Review of Santos Narrabri Gas Project Response to EIS Submissions

Dr Matthew Currell
Senior Lecturer
Program Manager (Environmental Engineering)
School of Engineering
RMIT University
Melbourne VIC 3000

May 2018

Figure 3-1 Groundwater monitoring locations in the Gunnedah-Oxley Basin

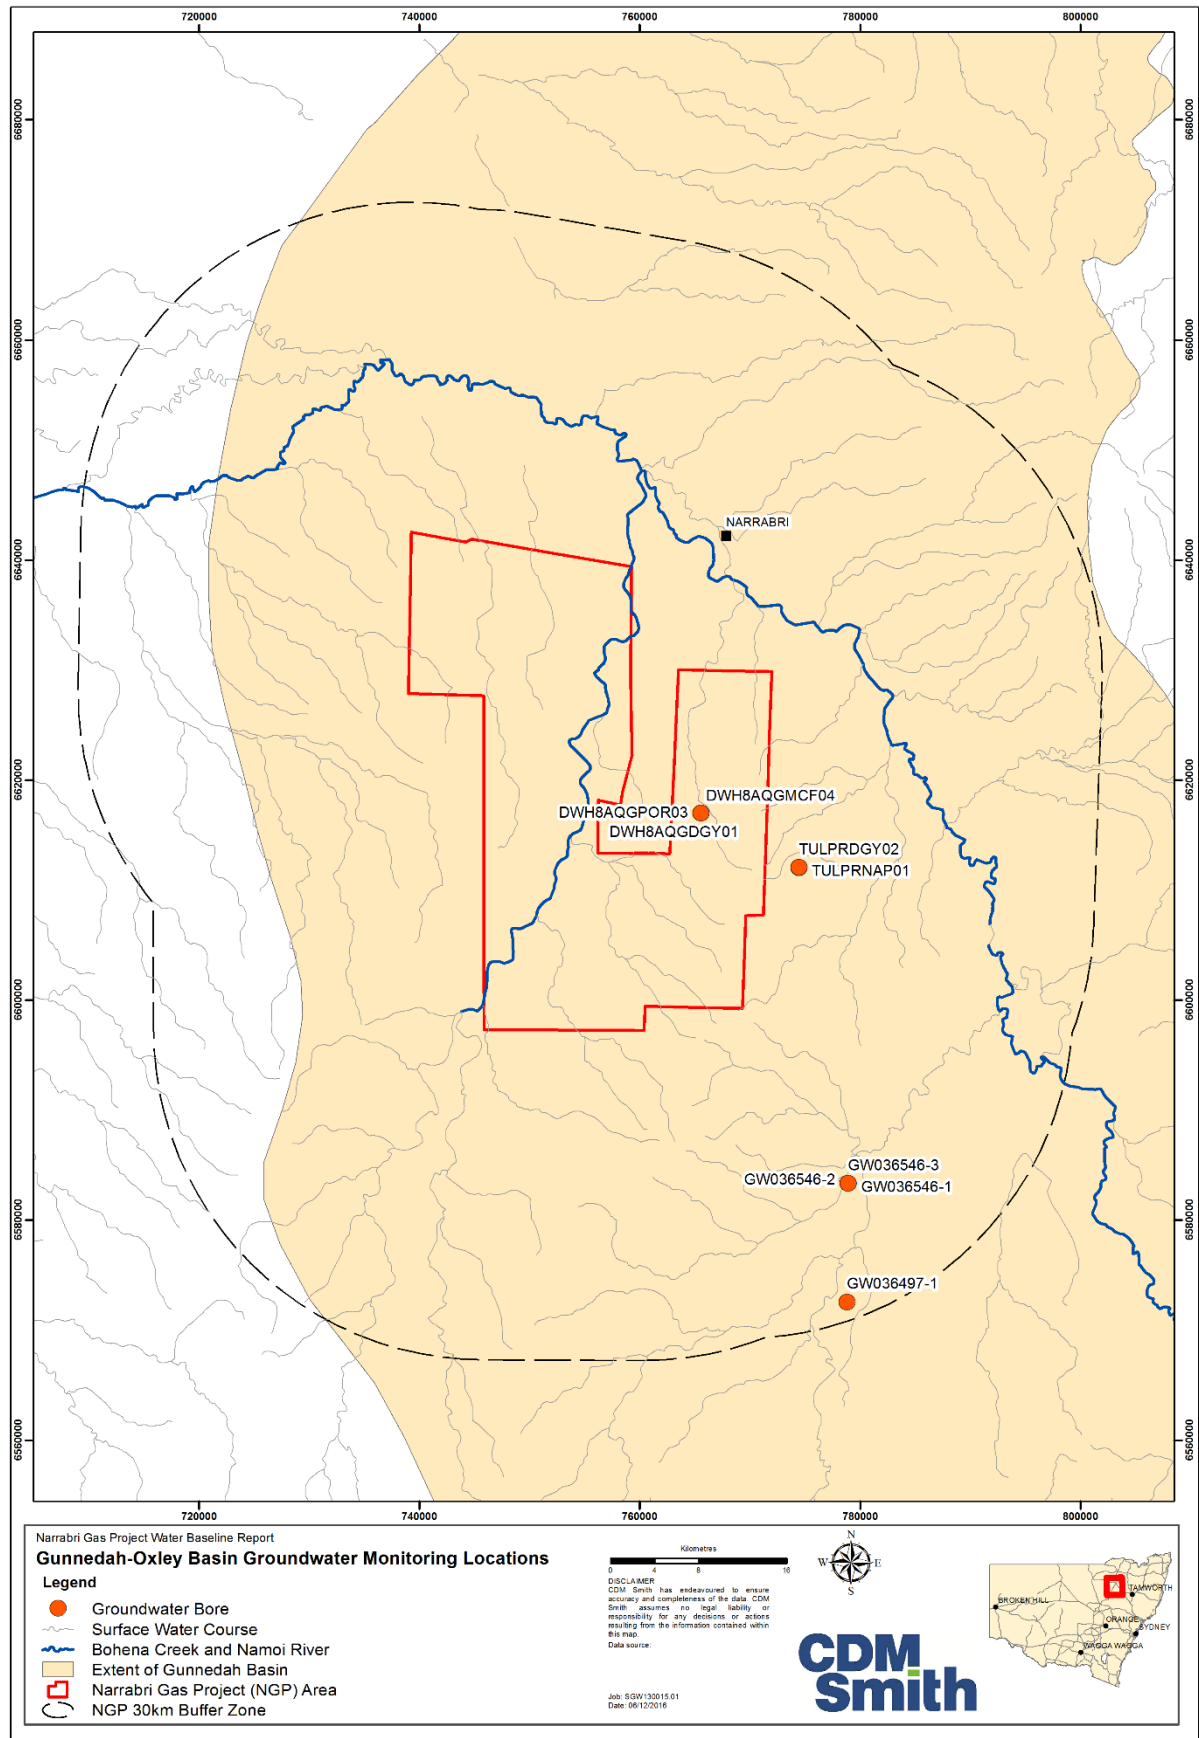
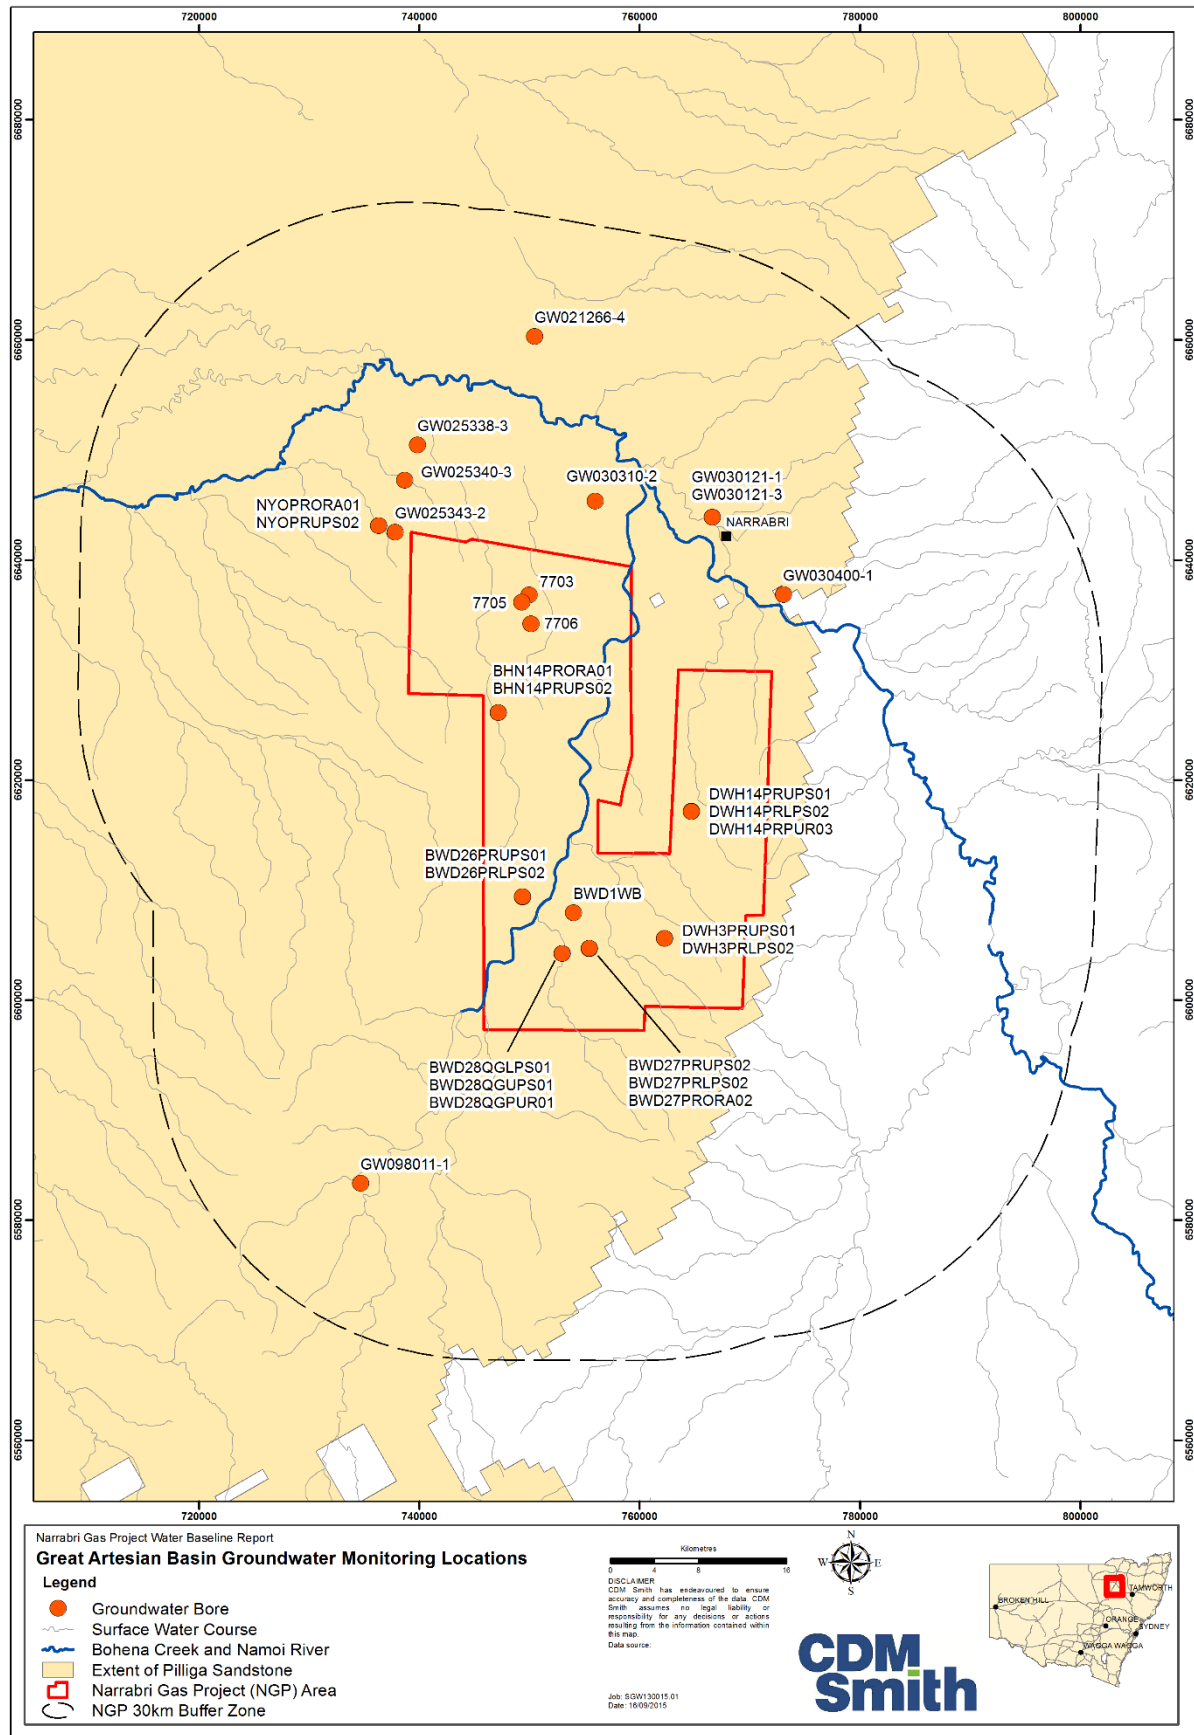
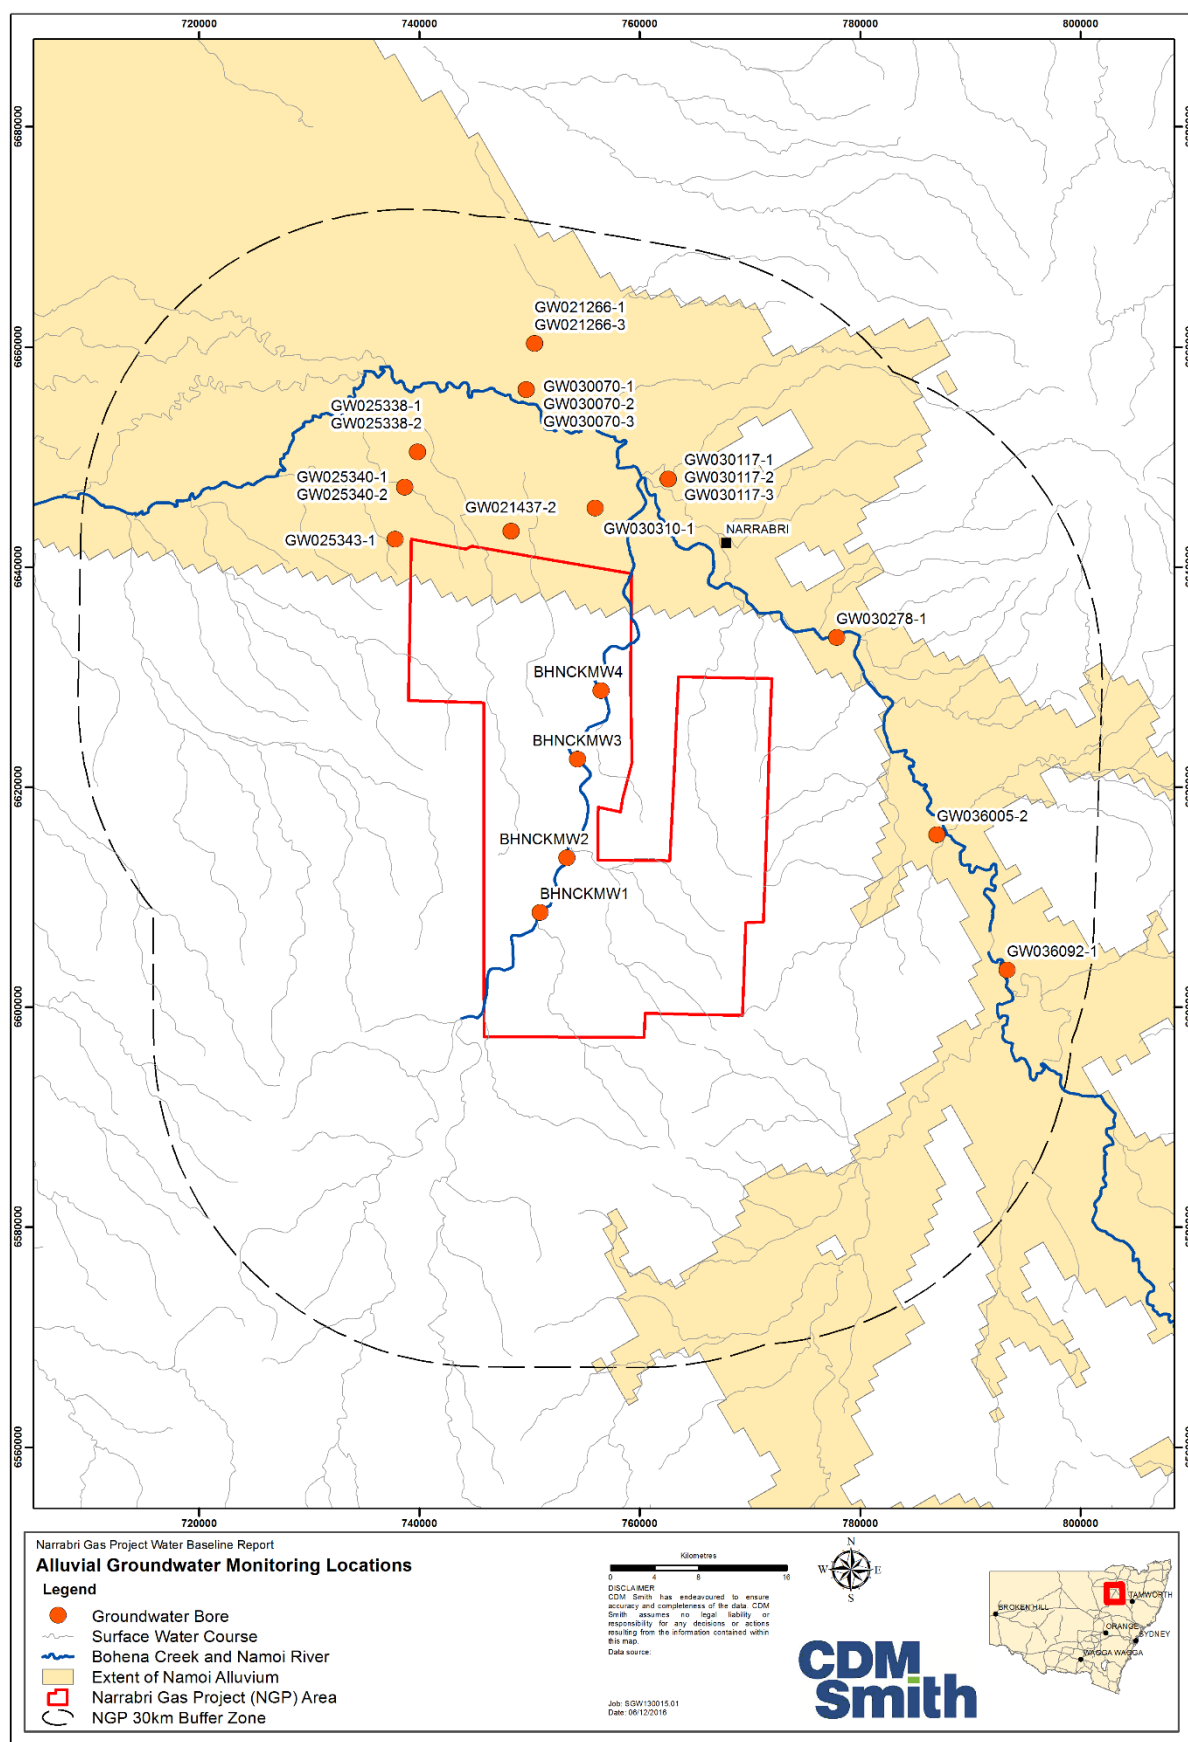
4. In my opinion, the spatial coverage of the groundwater monitoring regime required to adequately detect, characterise and mitigate such impacts as soon as they occur is poorly developed and at this stage is nowhere near commensurate with the size, numbers of wells and volumes of wastewater that would be produced. No significant change or update to the details of the groundwater monitoring program outlined in Appendix G3 of the EIS has been proposed, in response to the issues raised by Currell, (2017) and other submissions on the topic of groundwater monitoring in key agency submissions (such as the IESC and NSW EPA) and many non-agency submissions (e.g. see page 6-96 of the Response to Submissions Part A).

As noted above, there appears to have been little or no attempt to modify the produced water storage, transport and treatment system or revise the Project (e.g. by reducing the number of wells) to account for this issue; nor has any substantial proposal been put forward to increase the number of monitoring wells, frequency of monitoring or analytes monitored within the Pilliga Sandstone aquifer as part of the groundwater monitoring program. These remain significant oversights.

In spite of the high level of concern with respect to impacts on groundwater quality in the region expressed in Currell (2017) and many other submissions (including the IESC, NSW EPA and DPI), there has so far been no update or revision of the groundwater monitoring plan outlined in Appendix G3 of the EIS, and no drilling of additional groundwater monitoring wells to improve the poor spatial coverage highlighted in these submissions. The high ratio of gas production bores to groundwater monitoring bores, and the difficulty in assessing the proper siting of monitoring bores without further detail about gas well and other infrastructure locations, were flagged as major issues, yet these have not been addressed in the Response to Submissions in any substantial way. The Proponent responds to

With respect to groundwater quality monitoring, the lack of coverage of the monitoring network to guard against issues such as produced water leaks and spills has been highlighted above in section 1 of this report. The NSW EPA also indicated in their submission that the groundwater monitoring network was inadequate and that additional monitoring at produced water storage facilities should be agreed with NSW EPA. The Proponent relies on the assumption that 'seepage detection' monitoring at such facilities will be adequate to protect against any impact on groundwater quality. This ignores other important issues such as:
